Site Plan 2017-278

Zoning Review of the Height of the proposed structure

Drawing file: Zoning / Adjacent Building Grades Plan - Wright Pierce April 2018.pdf

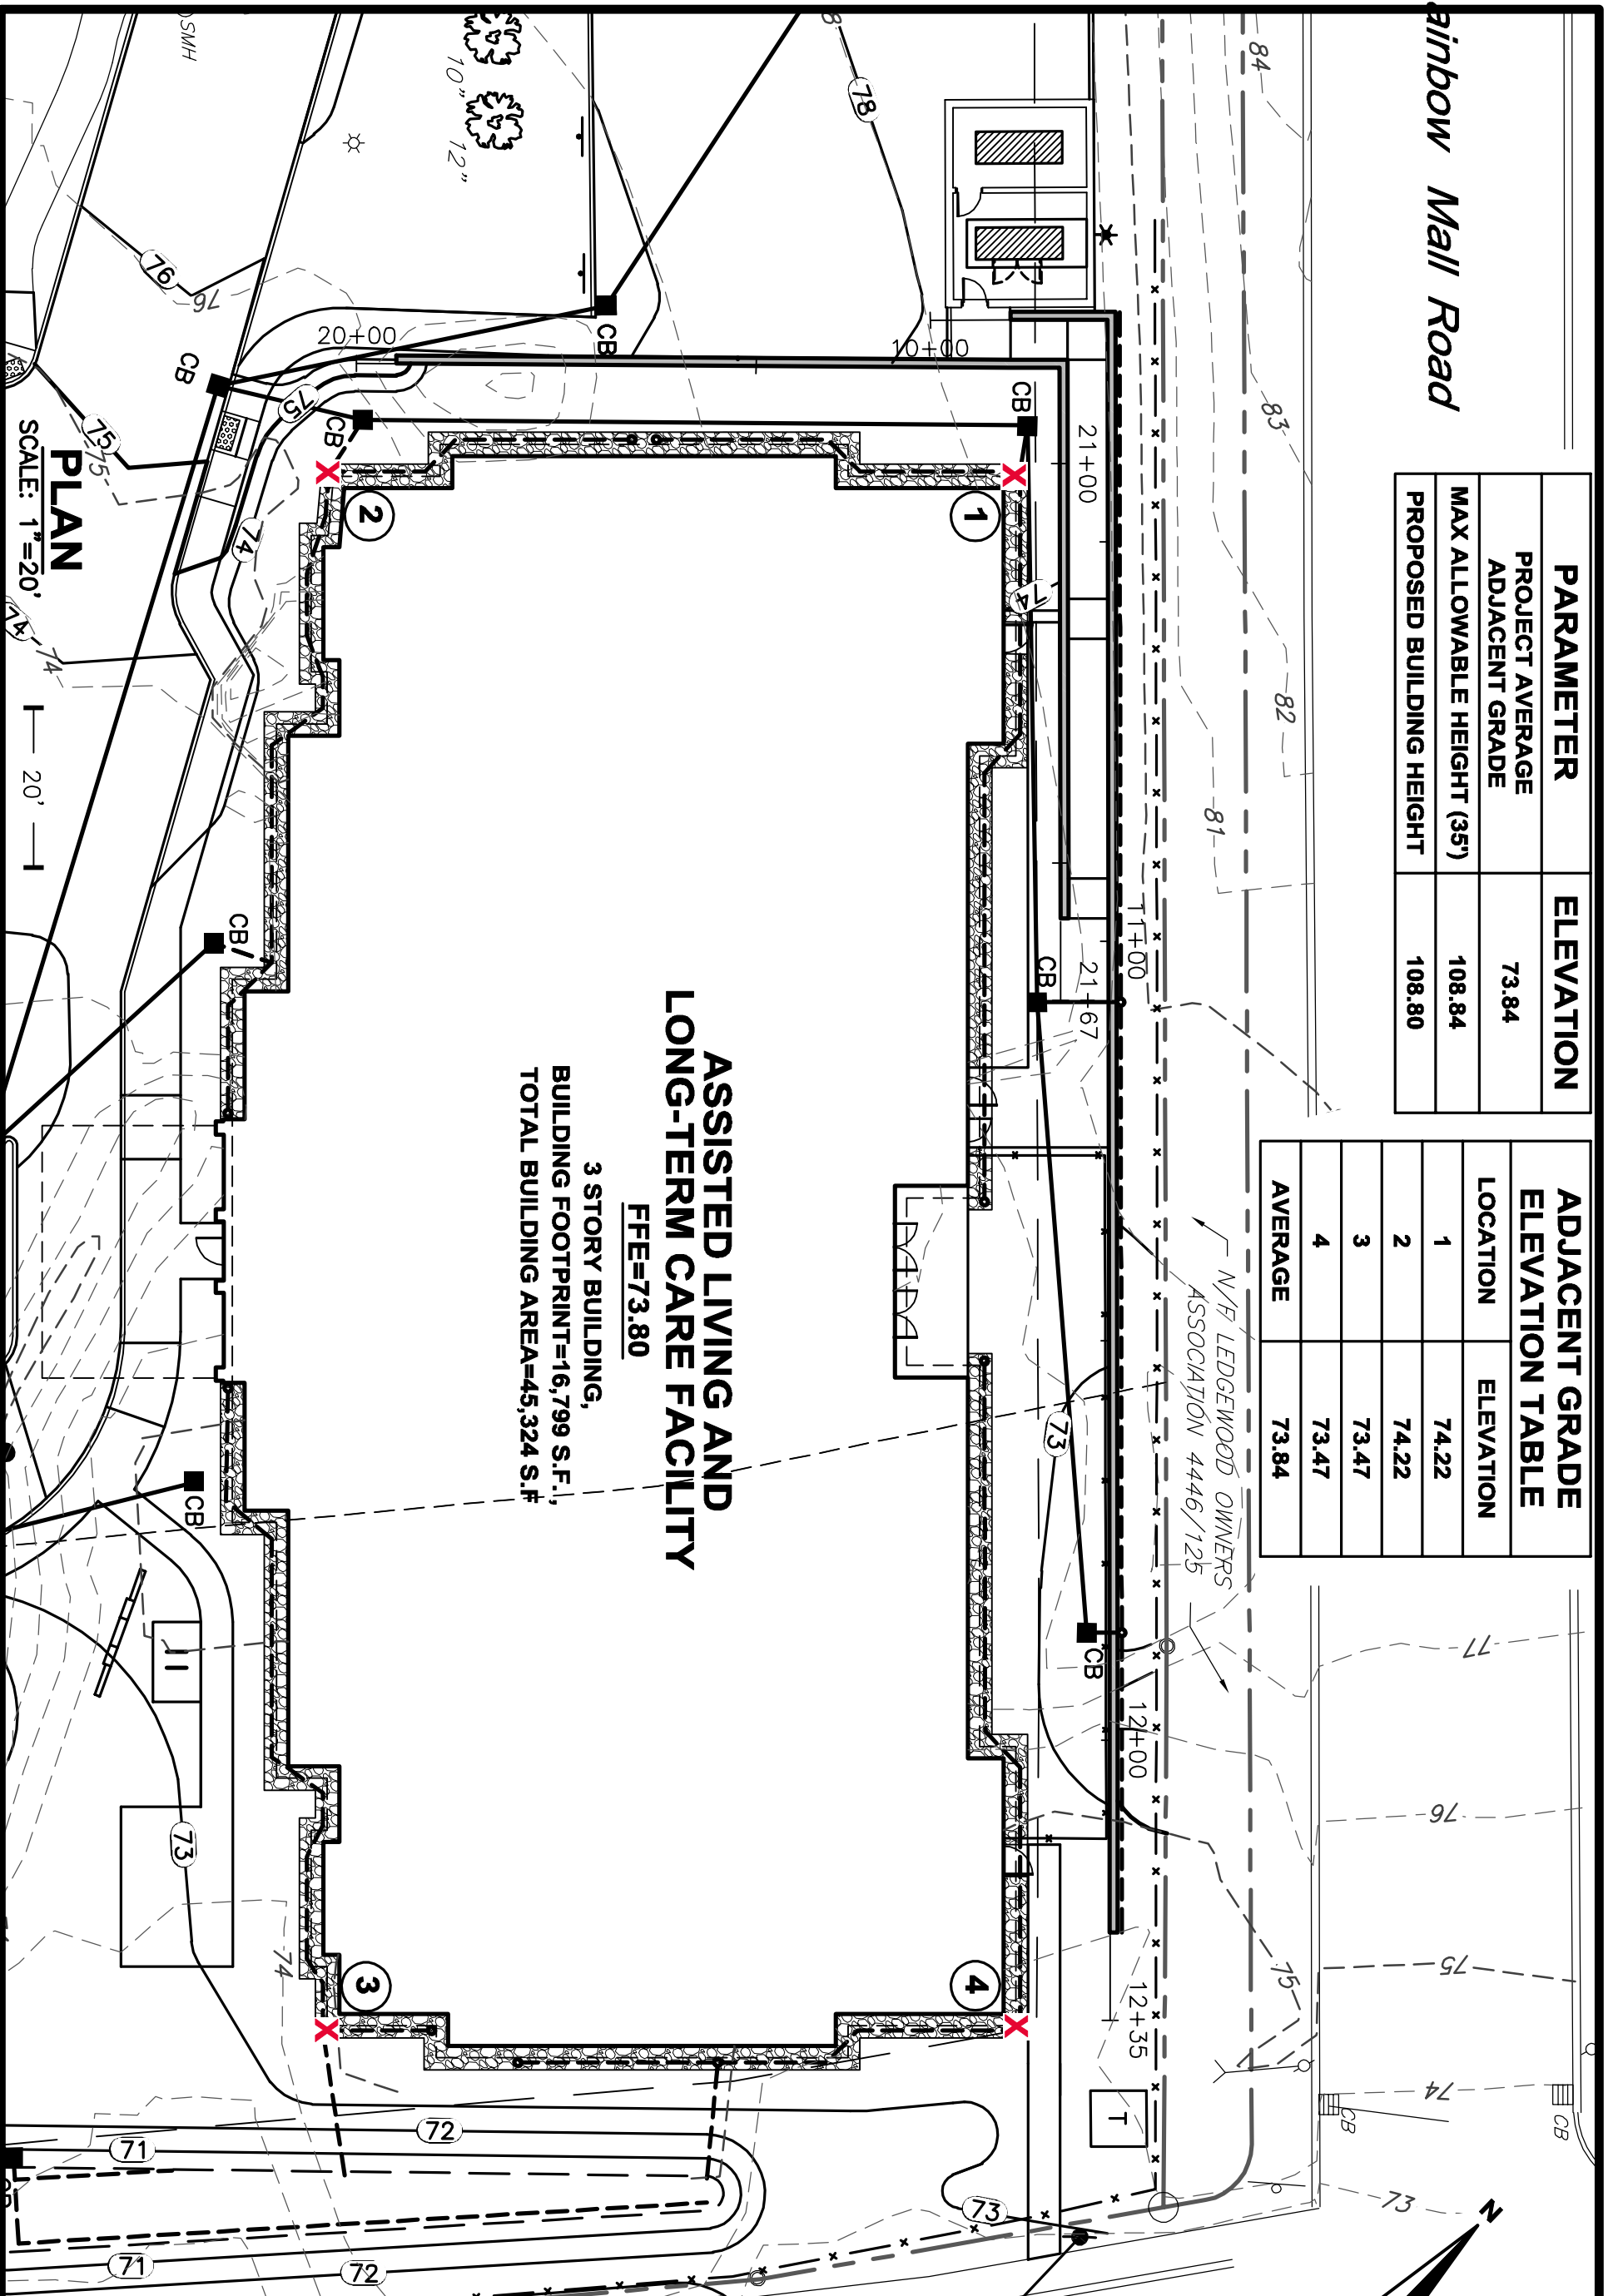
I need to know one thing before I can confirm that the height of the proposed building meets zoning. I need to know what the height is, measured from grade to the highest point of the roof beam. If it is measured from average grade, I need to know how the average grade was determined. The numbers on the plans in the document are too small to read.
